**DEPARTMENT OF PLANNING & INFRASTRUCTURE – MP07\_0070 MOD 1 –  
WOLLONGONG PRIVATE HOSPITAL**

Reference is made to your letter dated 19 July 2013 regarding the subject development forwarded to Roads and Maritime Services (RMS) for consideration.

RMS has reviewed the submitted information and objects to the modification. In this regard the following comments are provided for your consideration:

TRUE NORTH	Drawn	Checked	Date	Scale
	CQ	HMC	03.06.13	1:500 @ A3
PROJECT NORTH	Drawing Title PLAN - LEVEL 1

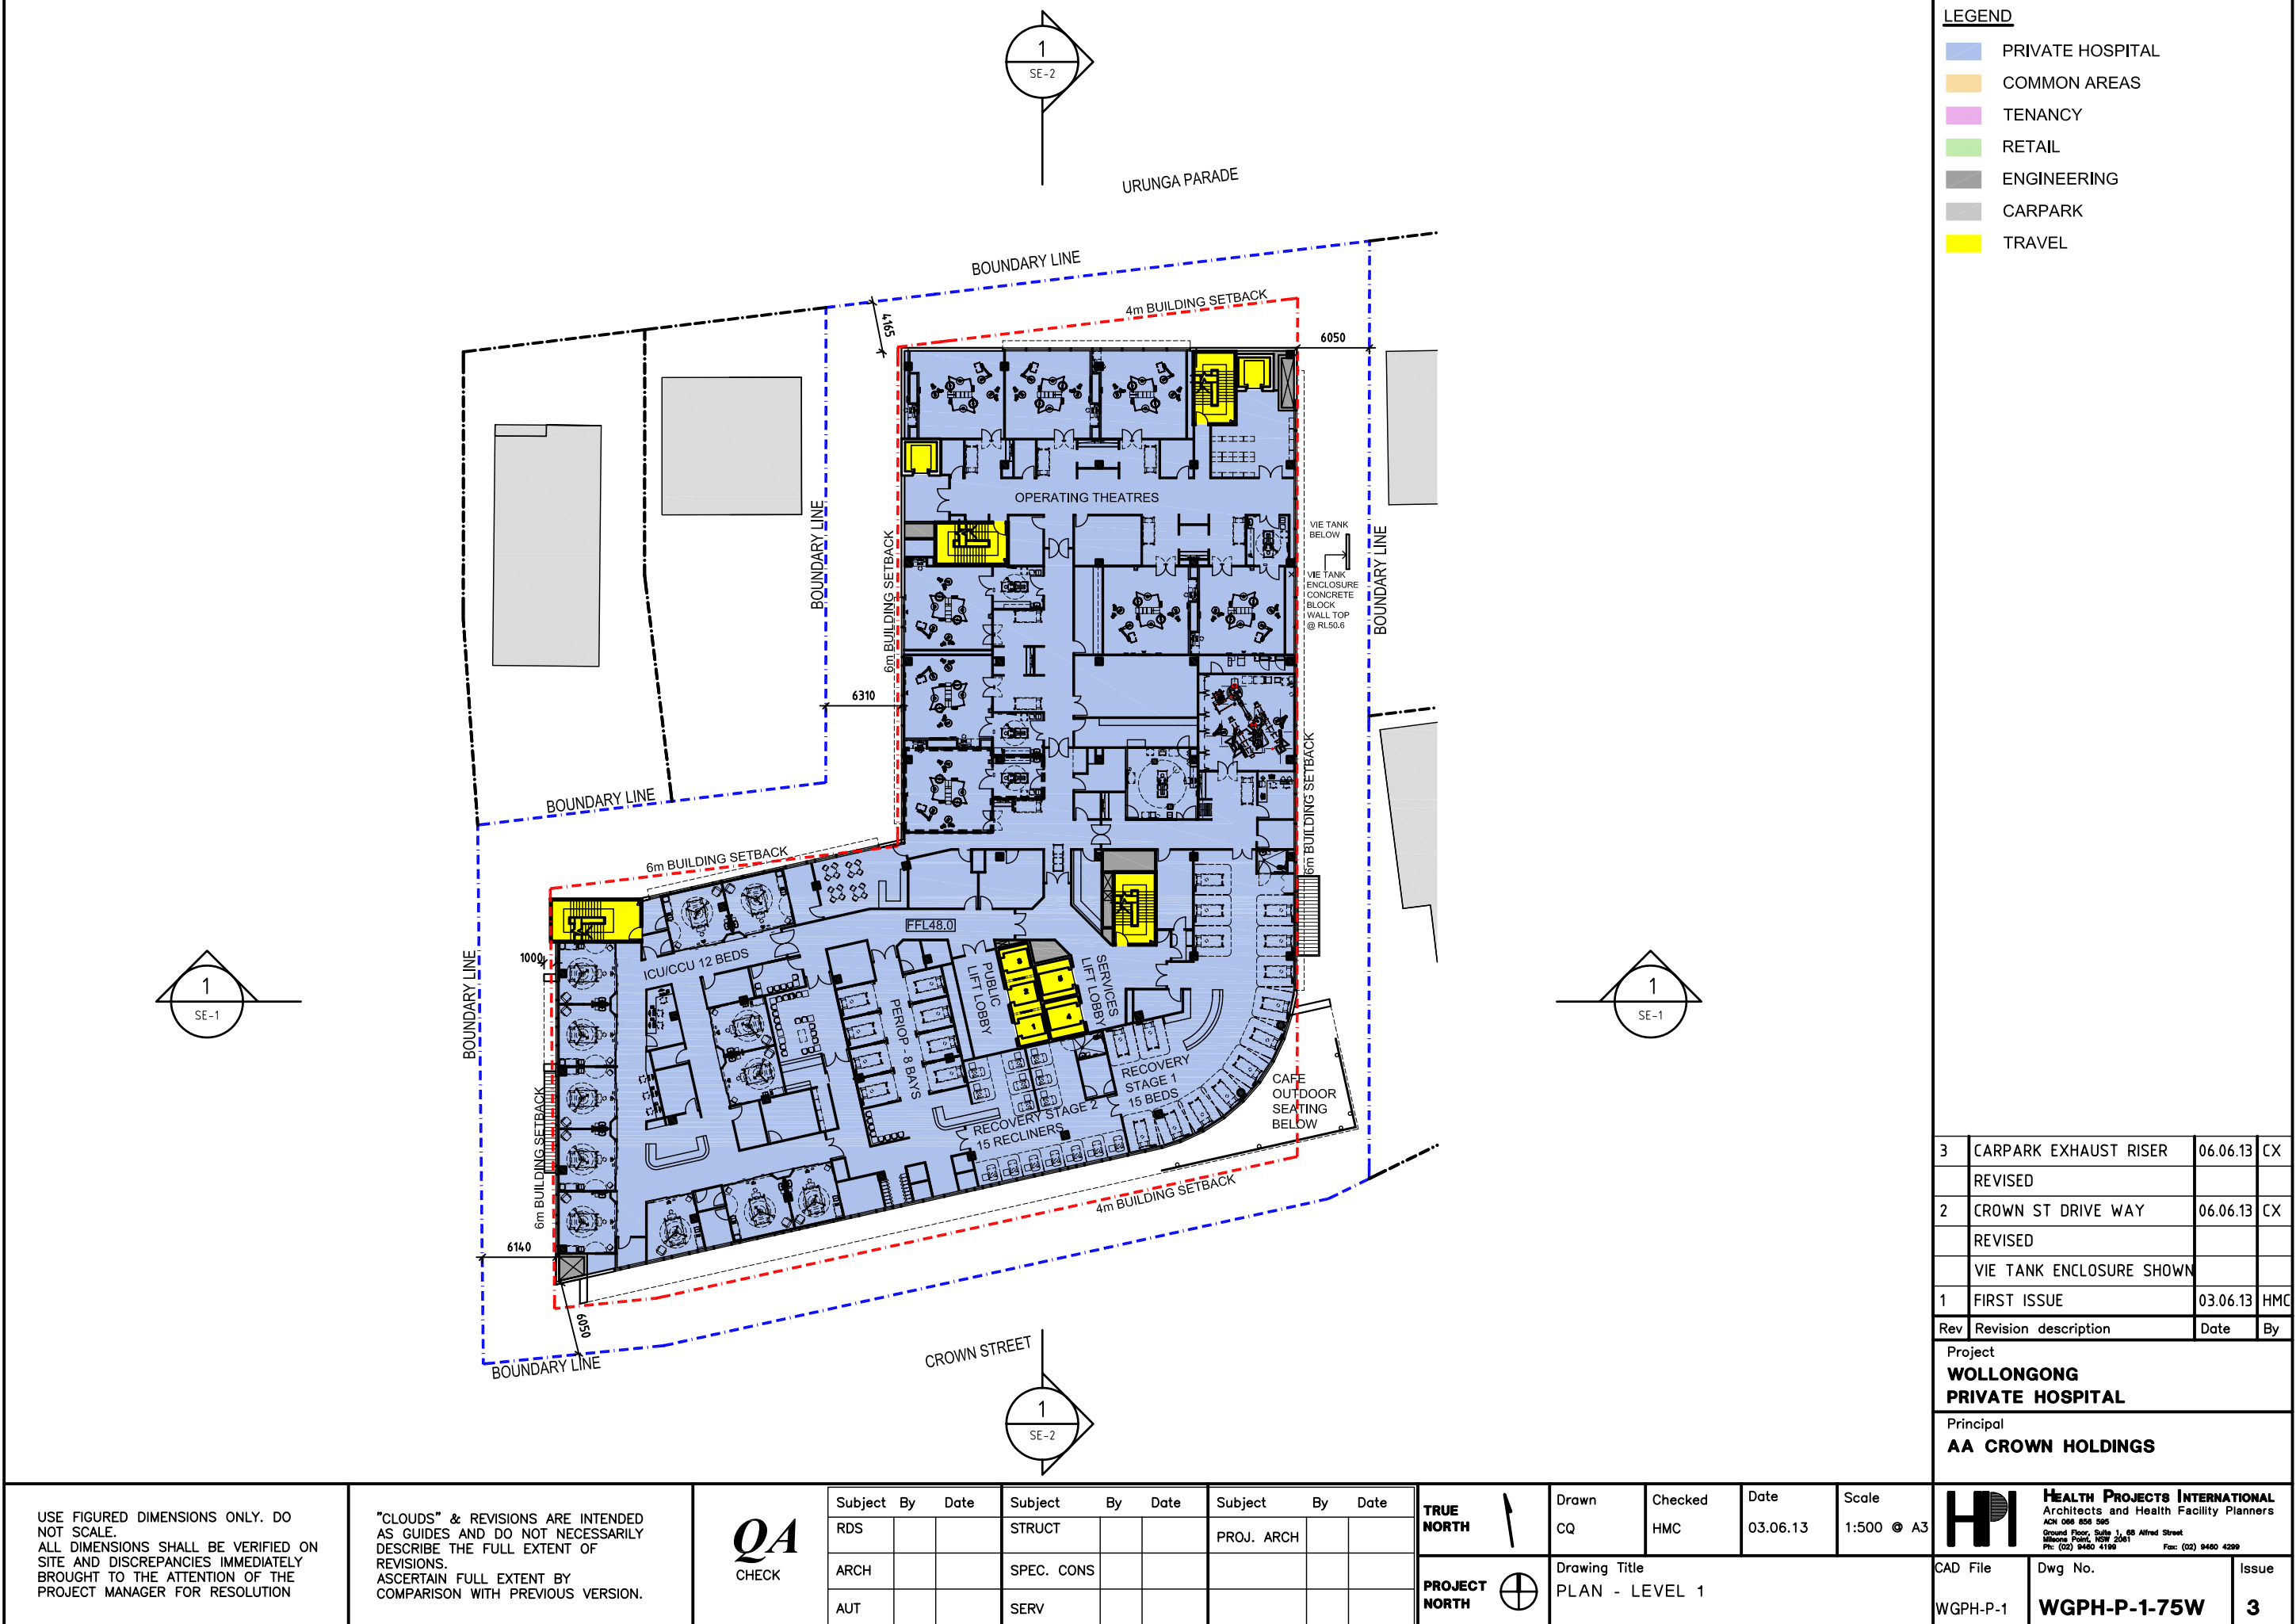
- In addition to RMS' concerns relating to the deletion of the Urunga Parade access, RMS has concerns with regard to the revised layout of the internal arrangements off Crown Street. Whilst RMS recognises that there are some benefits with the revised layout, RMS has concerns with the limited approach distance to the Crown Street access for vehicles exiting the development. This limited distance is likely to result in poor "loading" of the traffic signals, which essentially means only a few vehicles will be able to leave in any given traffic signal phase, leading to internal queuing. The internal queuing itself is not necessarily a concern to RMS unless the queuing leads to other internal queuing with vehicles waiting to drop off visitors. Such queuing could in turn create queuing back to Crown Street for vehicles entering the site. RMS considers that the developer needs to review the internal layout and improve the arrangements.

Drawn KC	Checked HS	Date 17.05.13	Scale 1:500 © A3
Drawing Title URUNGA PARADE AND WEST ELEVATIONS

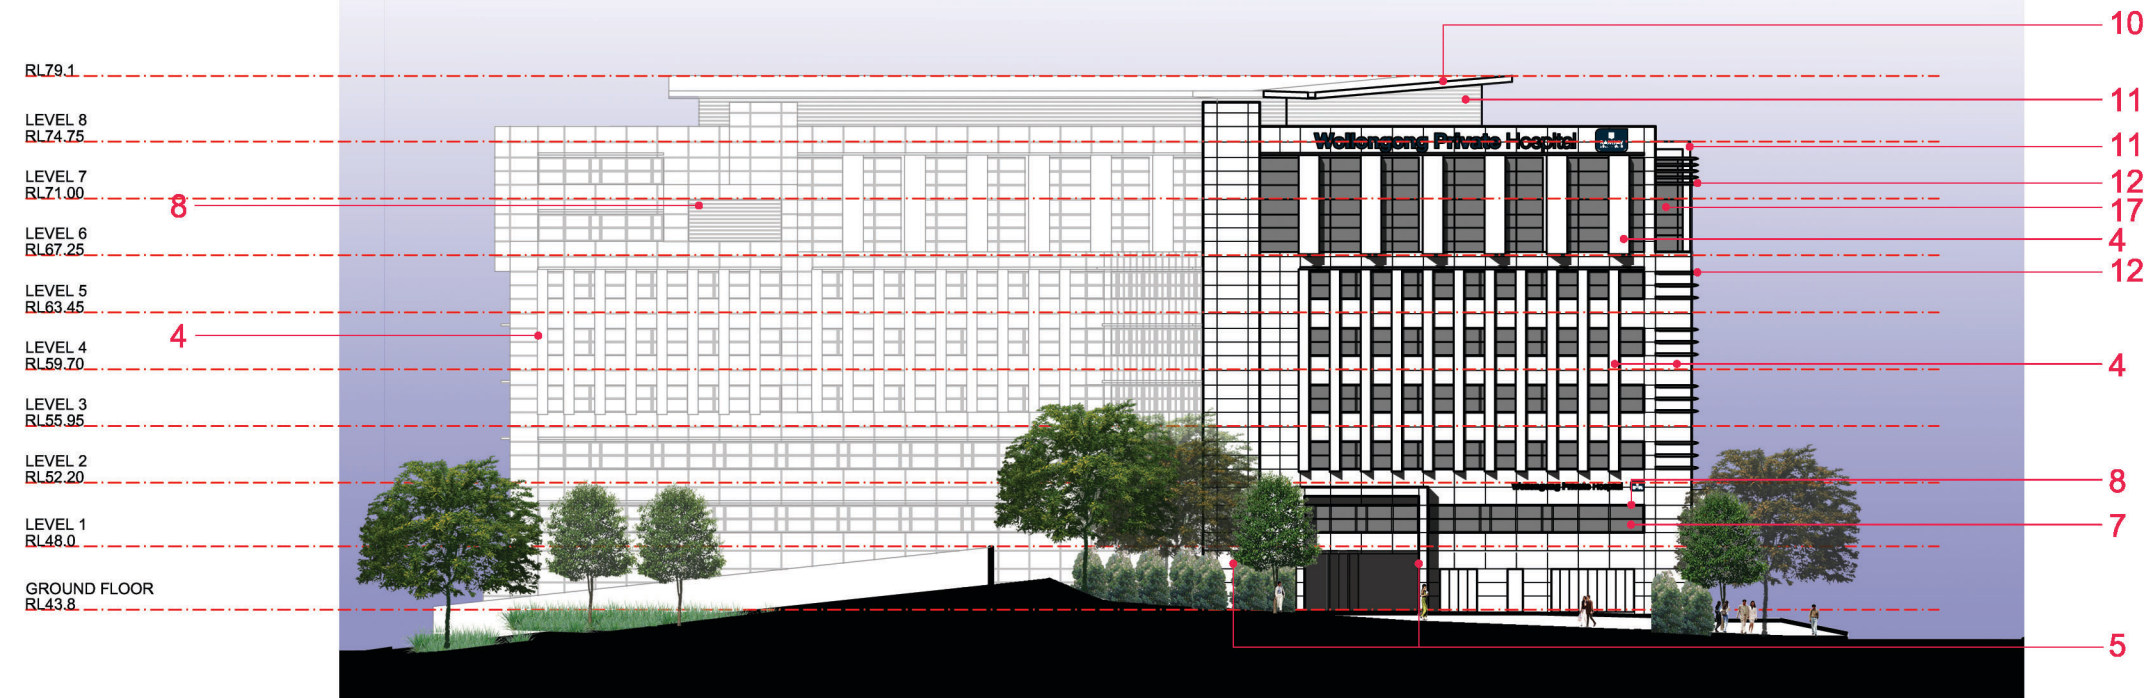
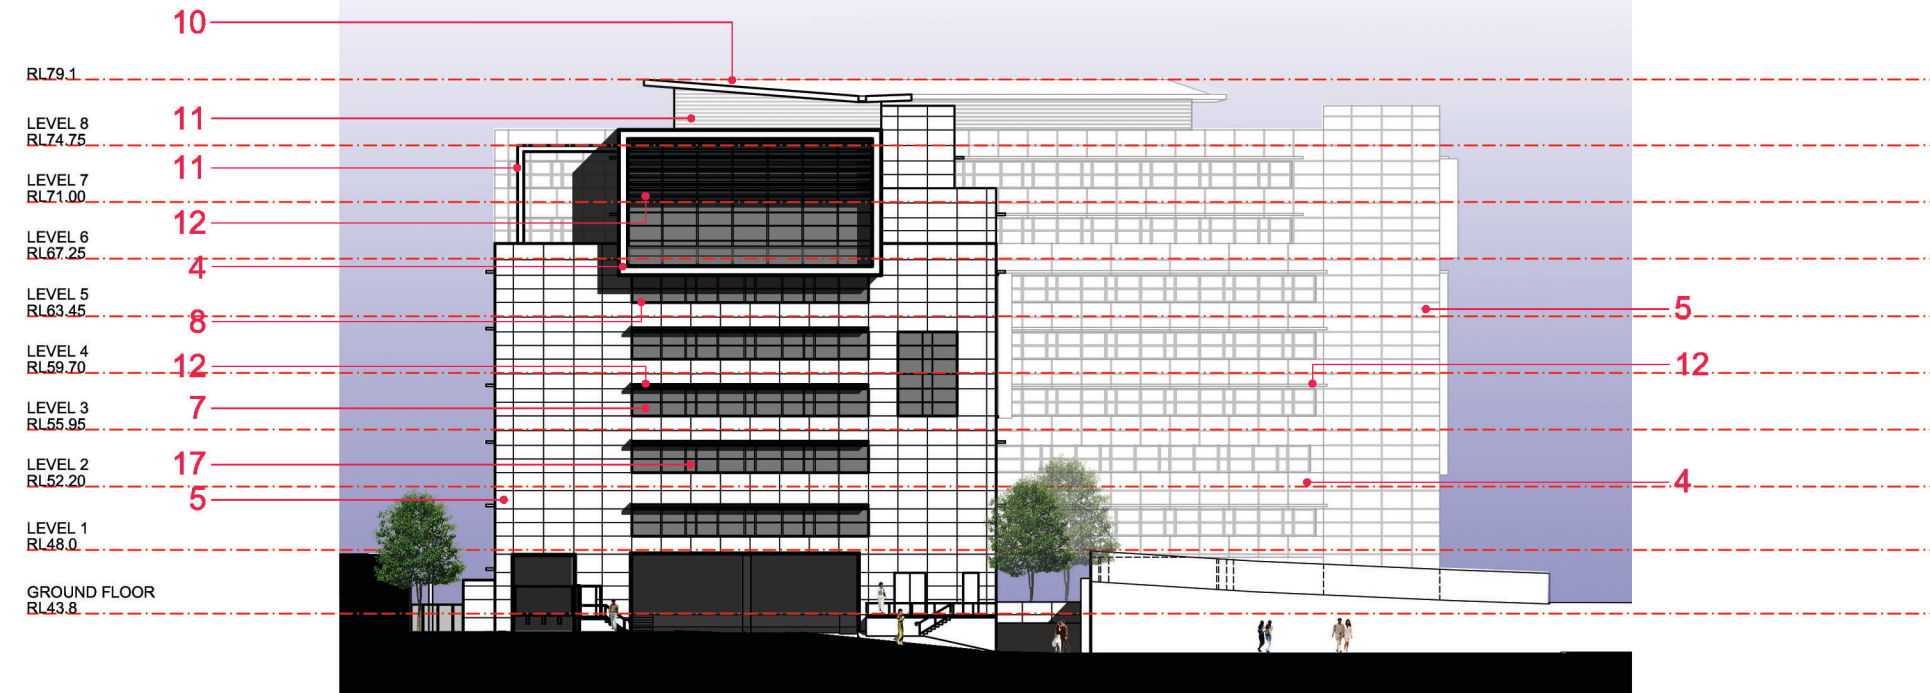
- RMS objects to the removal of the Urunga Parade car park entry. RMS highlights that the provision of this access in the original development was a fundamental part of RMS' decision to accept traffic signals to be provided on Crown Street. That is, without the access, RMS would not have accepted the provision of traffic signals or any other form of access on Crown Street.

- Notwithstanding the objectives of Clause 101 of the Infrastructure SEPP, RMS considers the Urunga Parade access is required to achieve appropriate network accessibility. As you would be aware, as part of the approved access arrangements the right turn from Crown Street into the development was prohibited to ensure queuing at the entrance did not compromise road safety or traffic efficiency. RMS considers that the provision of this access is vital in terms of network accessibility, particularly for trips origins in Gwynneville, Wollongong, North Wollongong and the entire northern suburbs

It should be noted that RMS will not provide the necessary approval required under the Section 87 of the Roads Act, 1993 for the traffic signals on Crown Street without an entry to the car park of Urunga Parade.
